Application No(s):	23/01233/OUT
Application site:	OS Parcel 4347 East Of Pipal Cottage, Oxford Road, Kidlington.
Proposal:	Outline application (with all matters except access reserved for future consideration) for the demolition of existing buildings and the erection of up to 800 dwellings (Class C3); a two form entry primary school; a local centre (comprising convenience retailing (not less than 350sqm and up to 500sqm (Class E(a))), business uses (Class E(g)(i)) and/or financial and professional uses (Class E(c)) up to 500sqm, café or restaurant use (Class E(b)) up to 200sqm; community building (Class E and F2); car and cycle parking); associated play areas, allotments, public open green space and landscaping; new vehicular, pedestrian and cycle access points; internal roads, paths and communal parking infrastructure; associated works, infrastructure (including Sustainable Urban Drainage, services and utilities) and ancillary development. Works to the Oxford Road in the vicinity of the site to include, pedestrian and cycle infrastructure, drainage, bus stops, landscaping and ancillary development

Figure 11 – Illustrative Masterplan

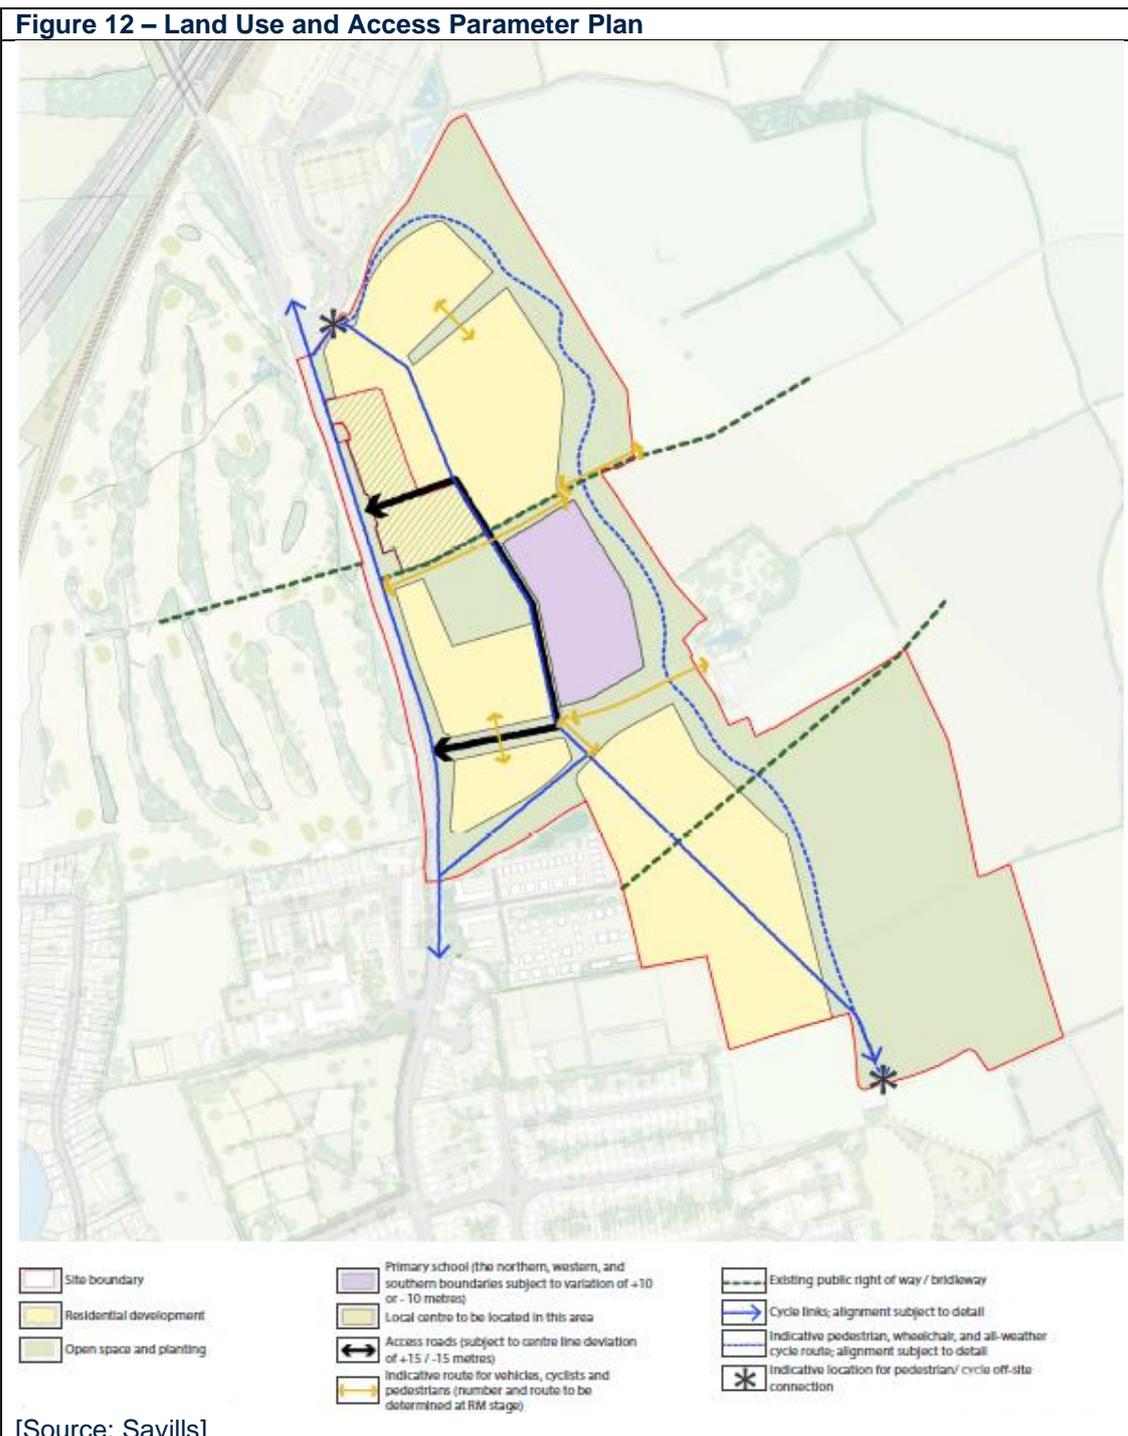
The position of the local centre on the illustrative masterplan roughly accords with the Development Brief adjacent to Pipal Cottage and the historically associated farmstead. The proposed school of up to 11m (from finished ground level) has moved southward, closer to the Grade II* St Frideswide Farmhouse, in place of what would have been allocated as 2-3 storey housing.

The Land Use and Access Parameter Plan shows the local centre wrapping around Pipal Cottage but the illustrative masterplan shows the local centre west of the proposed school site, and south of Pipal Cottage – please confirm which is correct. See further comments on heights, land use, setting, and buffers under section ‘Layout, density and building height parameters.’

Figure 13 – Building Heights Parameter Plan

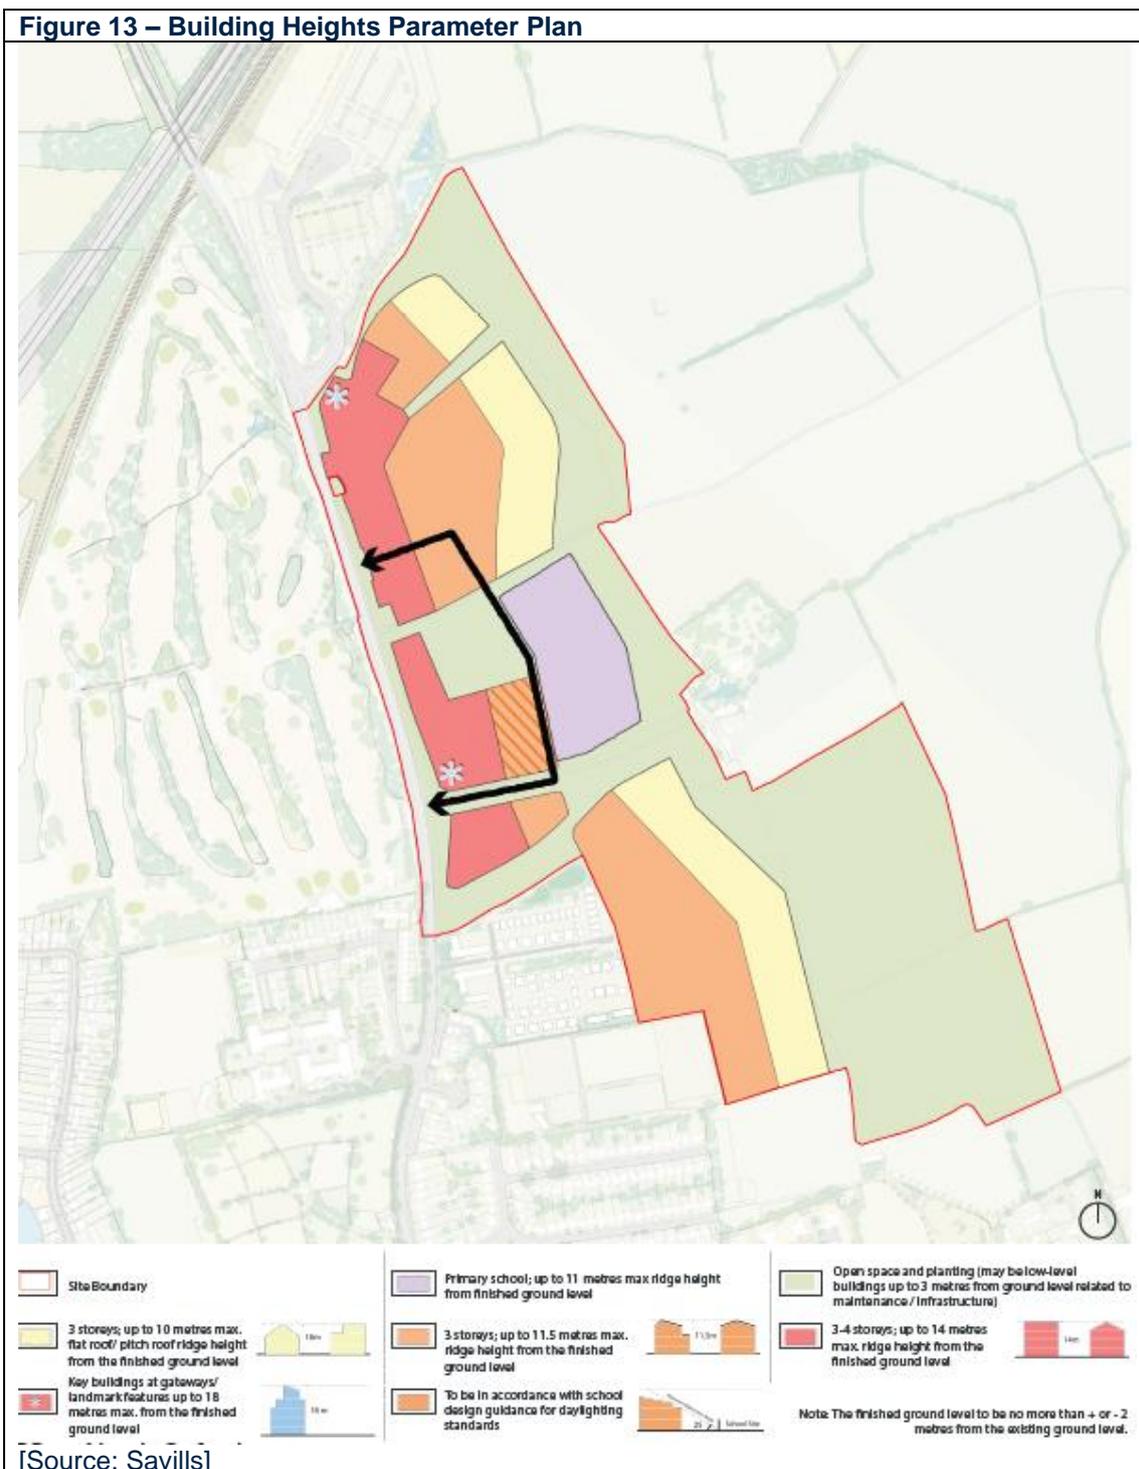
Site sections/sectional elevations which include the designated heritage assets and the non designated heritage assets 'as existing,' 'as proposed' and with the 'worst case scenario' should be produced. Instead of agreeing height parameters above finished ground levels, which could vary by +/-2m, heights should be in relation to fixed levels such as the ridges and eaves of St Frideswide, her farmstead, Pipal Cottage, and Pipal Barns, so things become more tangible. This would inform the scale of development that is likely to be acceptable in this part of the site, and what mitigation measures are needed. The proposed 14m +/-2m would be too tall, we therefore need to agree appropriate heights adjacent to Pipal Cottage and Pipal Barns.

Key landmark buildings need high quality design, they do not need to be tall; 18m +/-2m from finished ground level, is not considered appropriate or justified.

Section 6 of the Development Brief included development principles for a mix of 3-5 storeys towards the Park and Ride, and towards Oxford Road – this is comparable with new development in the local centre in Summertown, a dense Victorian suburb of Oxford. Historic houses in Cherwell tend to have quite low ceiling heights, below the standard 2.6m floor to floor. 2-3 storeys are proposed heights of building to the south and south west of St Frideswide – up to 10m, and up to 11.5m where the ground also rises (+/-2m from finished ground levels, not fixed points such as eaves and ridge heights of the heritage assets). We need a further building height parameter to be introduced to ensure heights are dropped near heritage assets.
